NORFOLK BOREAS

Oulton Parish Council's response at deadline 6 to the Applicant's response to written questions at deadline 5

Figure: 24.5	Drawing No: PB5640-006-024-005				
Revision:	Date:	Drawn:	Checked:	Size:	Scale:
01	18/02/2019	JT	CD	A3	1:300,000

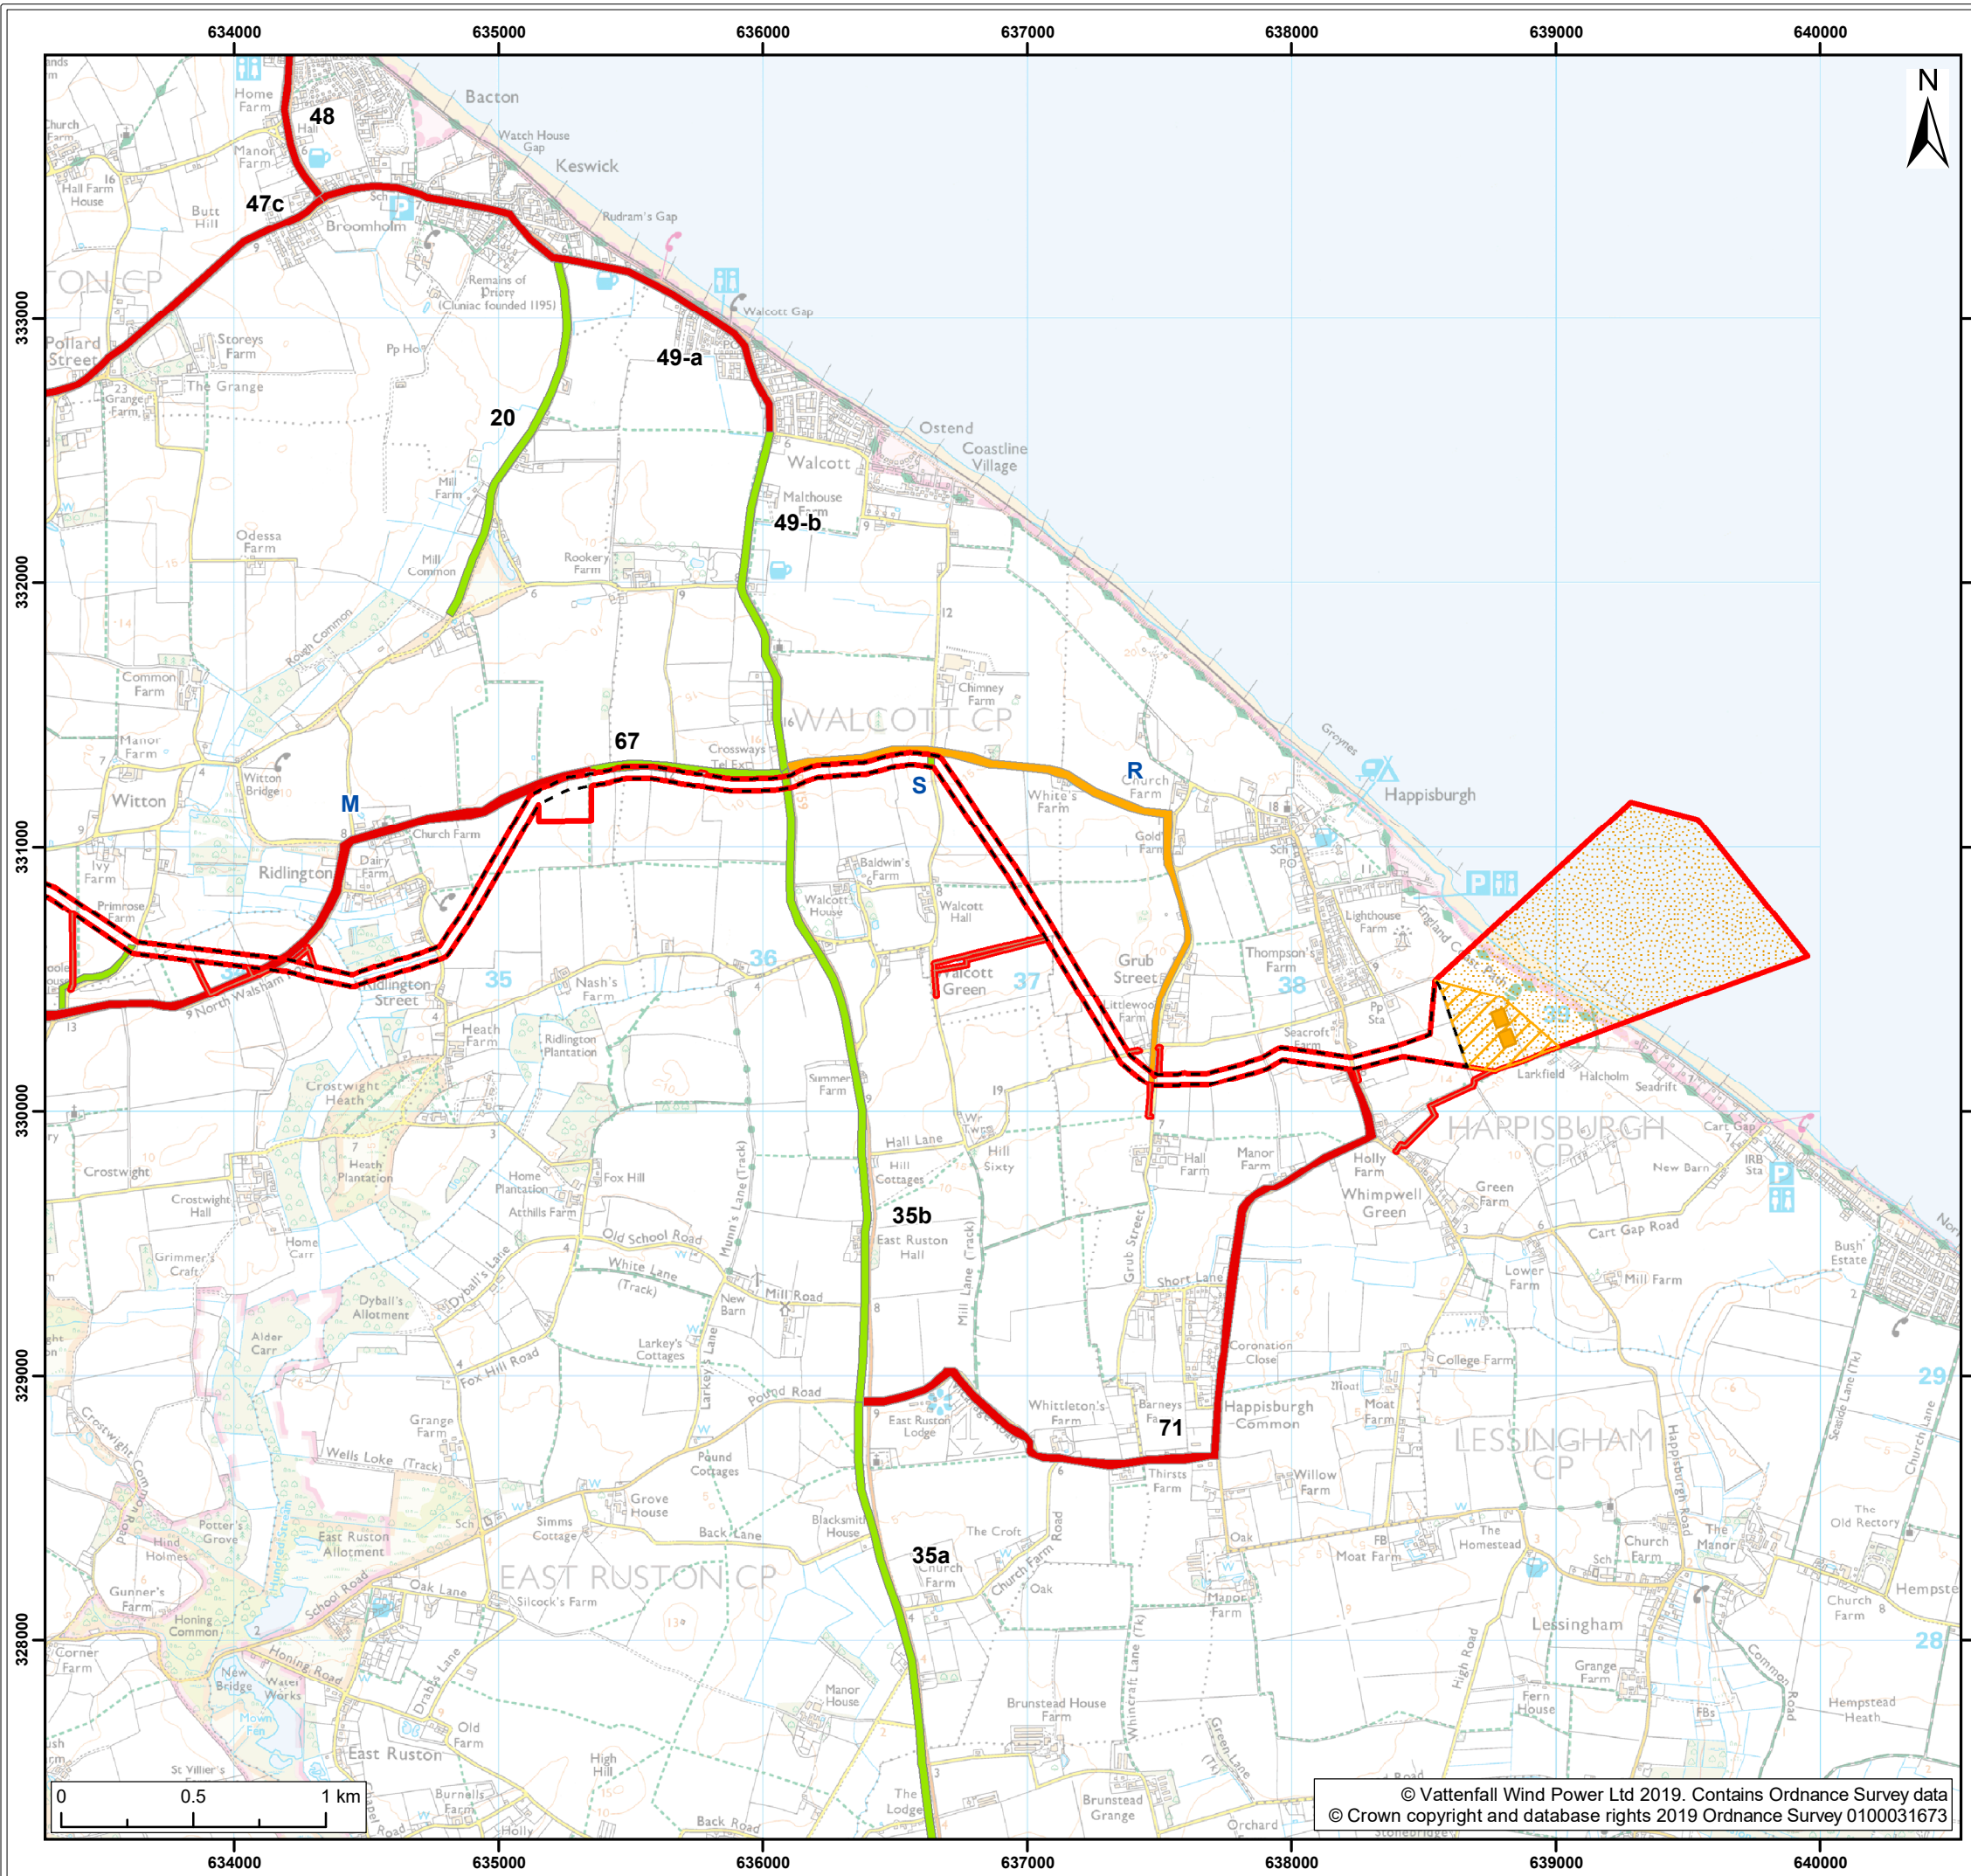
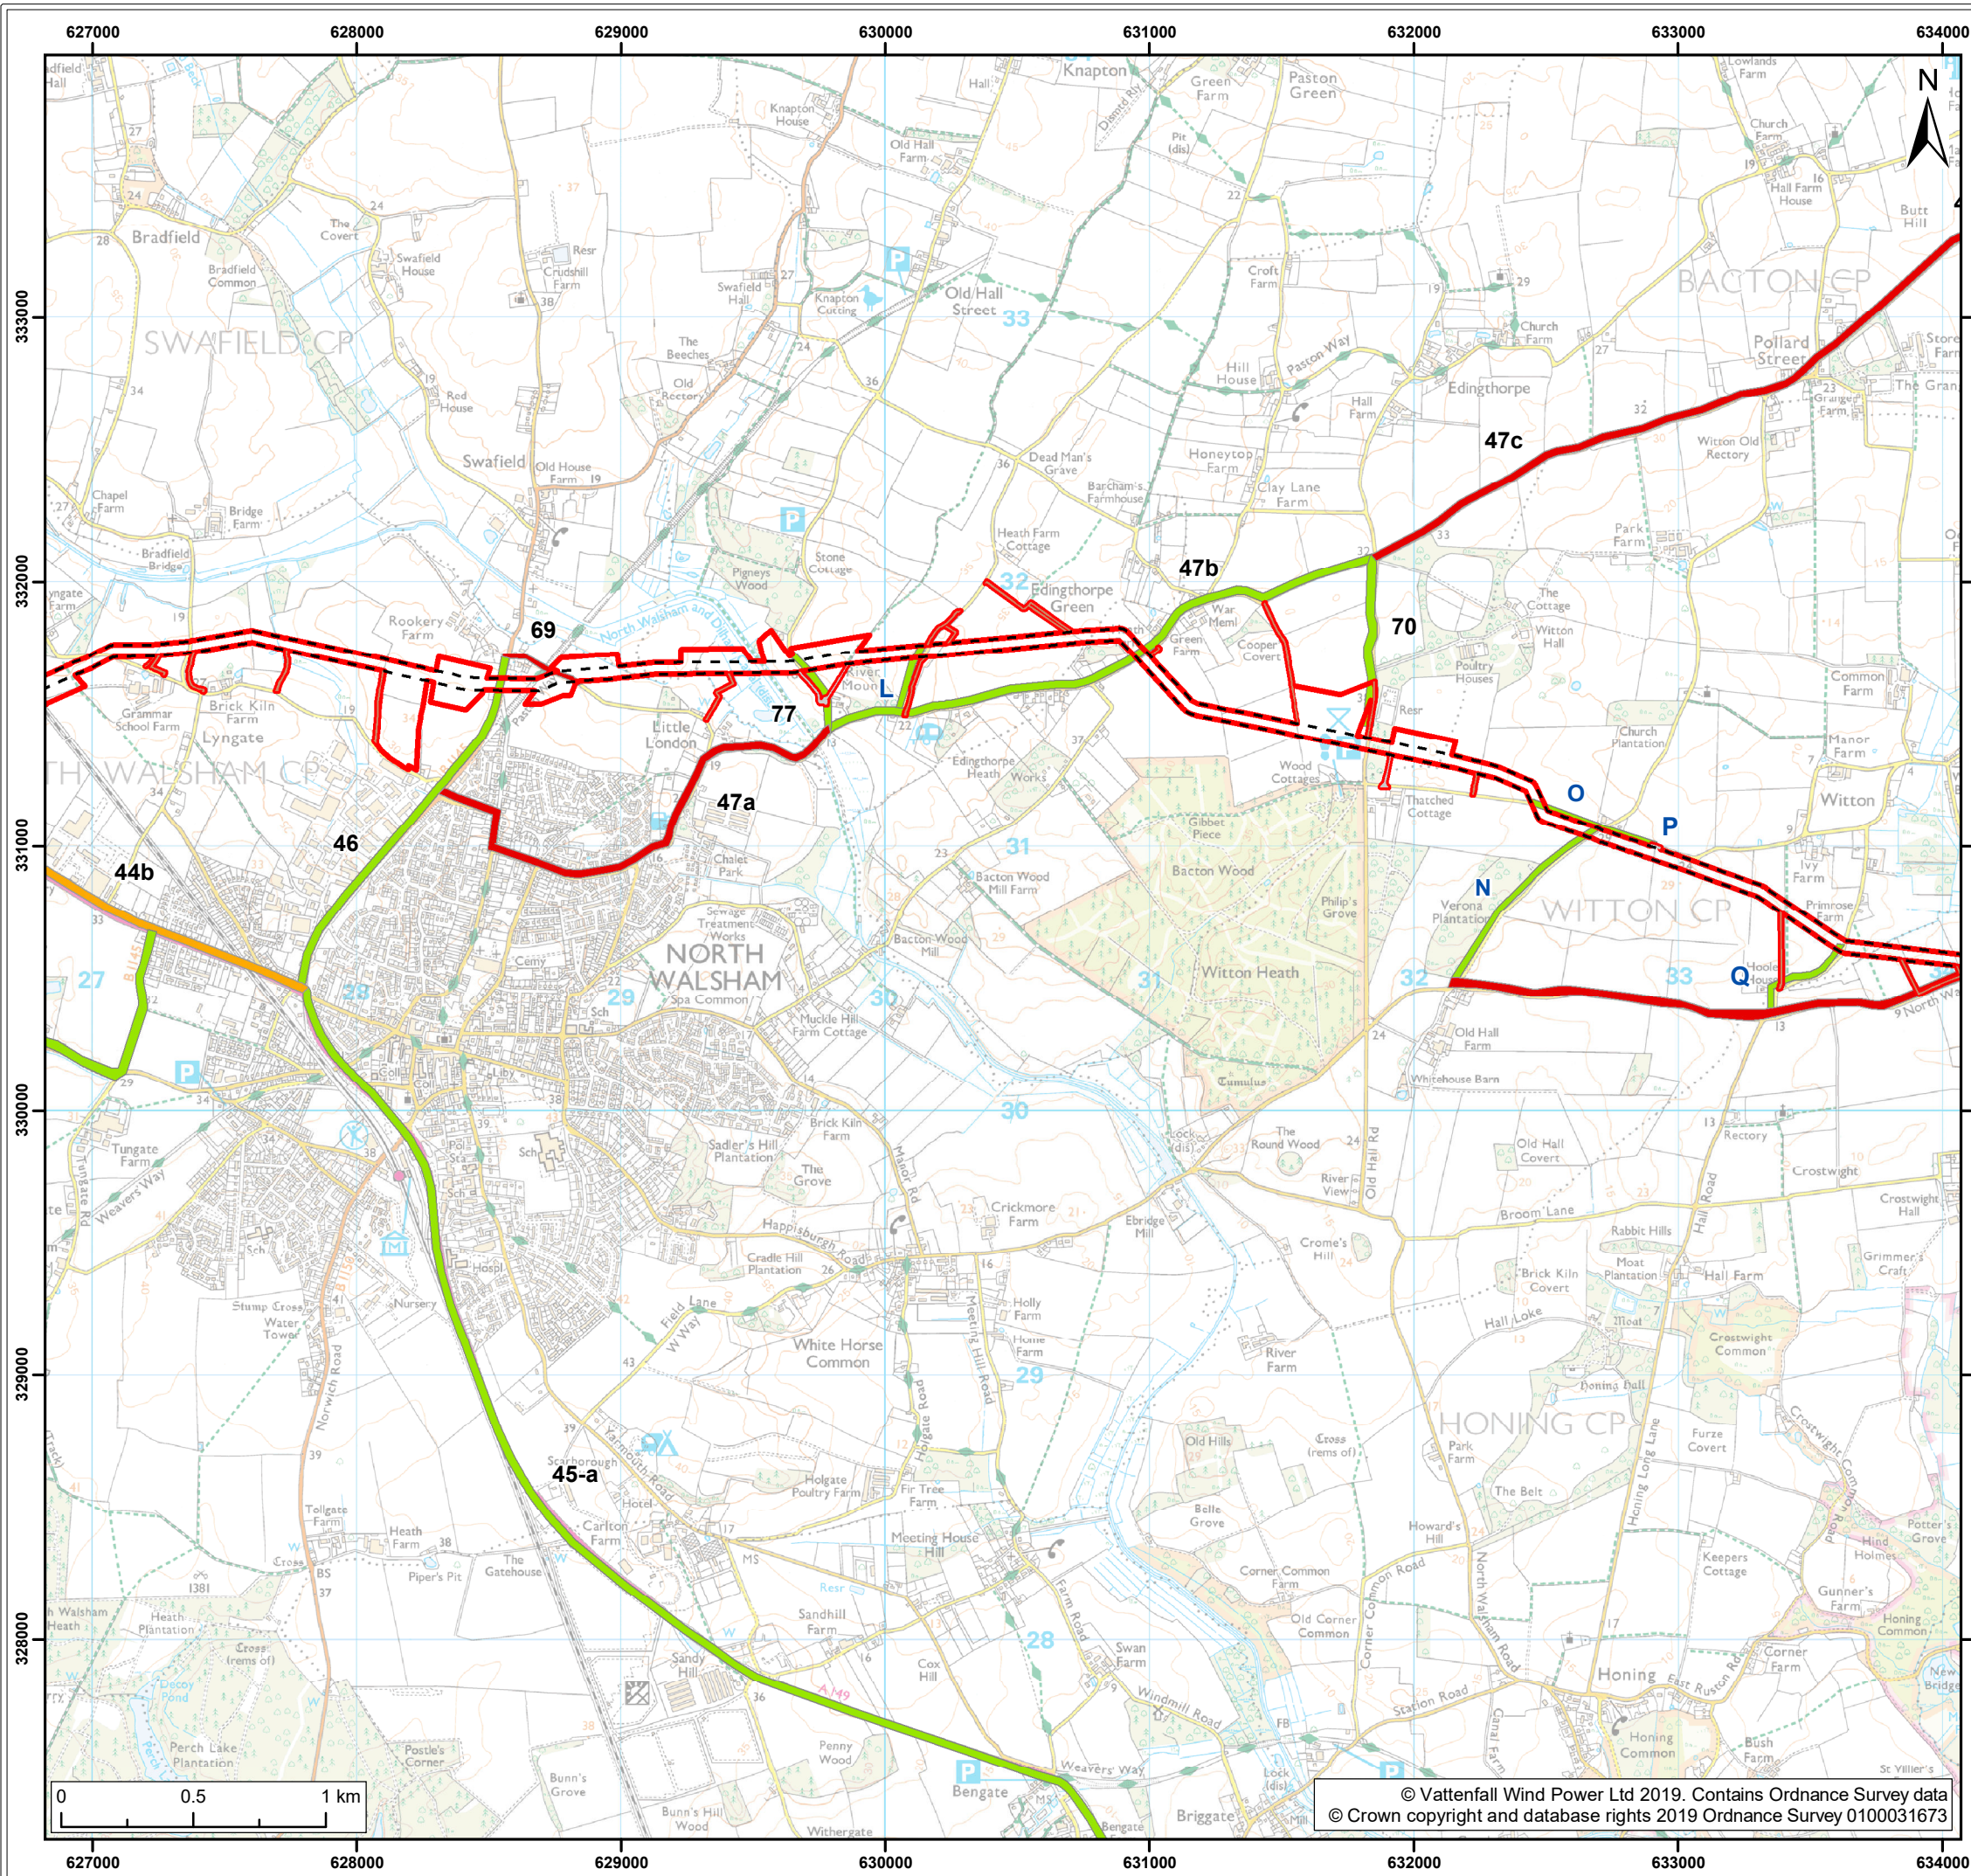
The assessment established that Link 68 has no national, regional or local designation as a cycle route/walking route and therefore is not a sensitive link with respect to those user groups. Therefore, the mitigation proposed for Link 68 was not specific to NMU but developed for all modes. ”

OPC note that the Applicants have dismissed Link 68 as a cycle route, as it is not designated. This is incorrect and extremely misleading. It should be noted that Link 68 is used by many individual cyclists, often by cycling clubs from near and far, doing a circuit from Aylsham or Norwich, and those who wish to join up with the Blickling Cycle route, along with Itteringham village shop/cafe off Link 75. It is also seen as a “safe” circular route for joggers, families with young children cycling out informally from Aylsham - across Abel Heath, along Heydon Road, up Oulton Street and back via Aylsham Road.

In fact, there are 3 designated cycle routes (figure1-3) that pass either along or near Oulton Street.
